EPC STORMWATER REVIEW COMMENTS  
IN ORANGE BOXES WITH BLACK TEXT

# SADDLEHORN RANCH - FILING 4

# CONSTRUCTION DOCUMENTS

BARROSITO TRAIL CL PROFILE (2)
 STA 55+00.00 TO 64+00.00

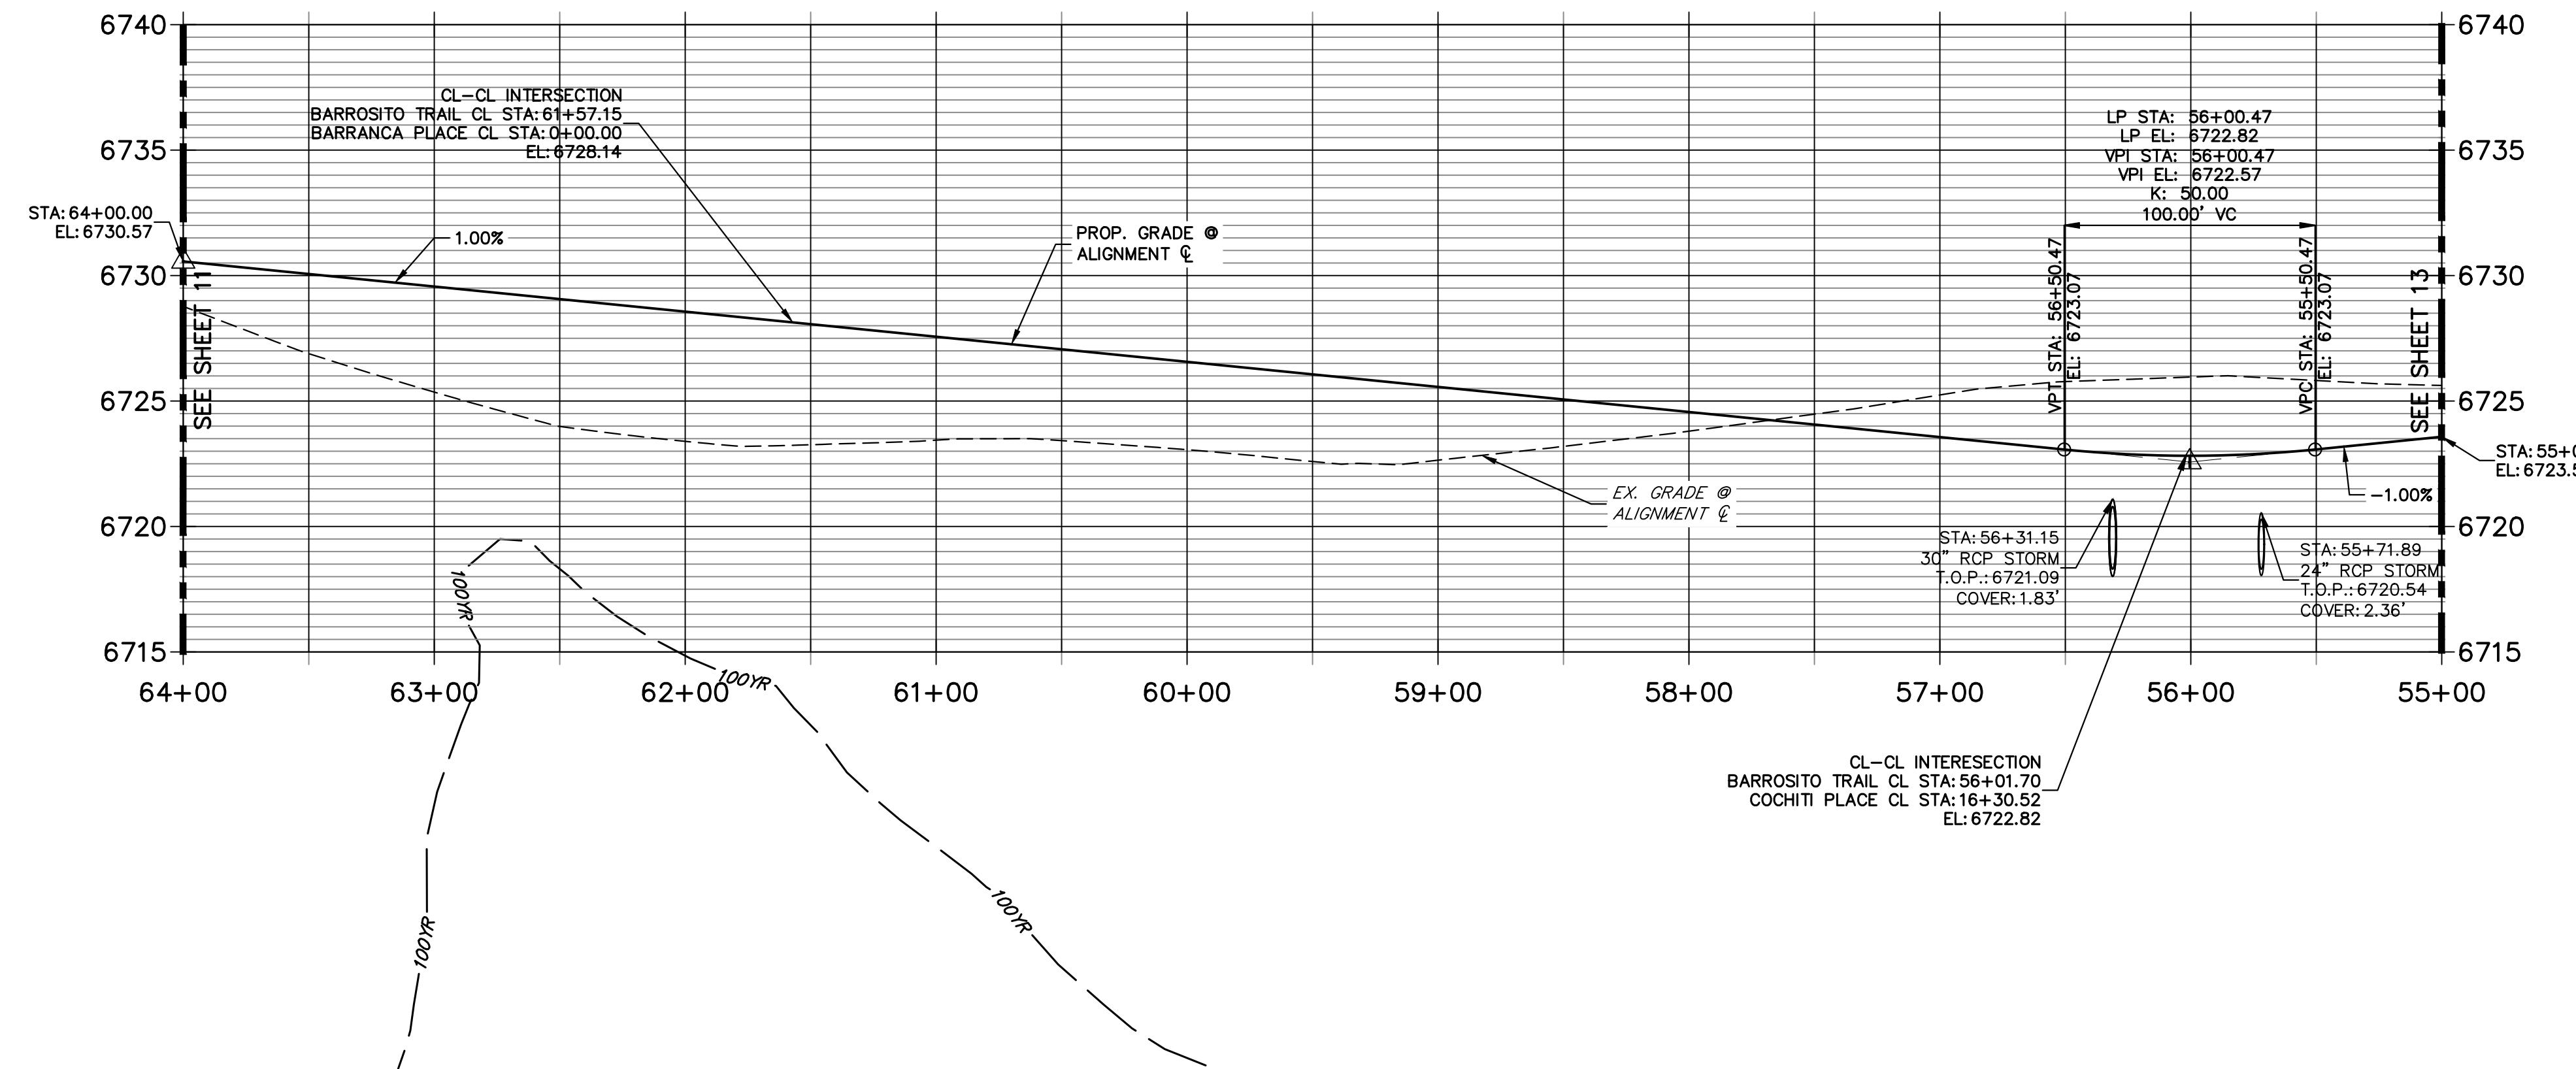
Unresolved from Submittal 1 - Show no build easement lines.
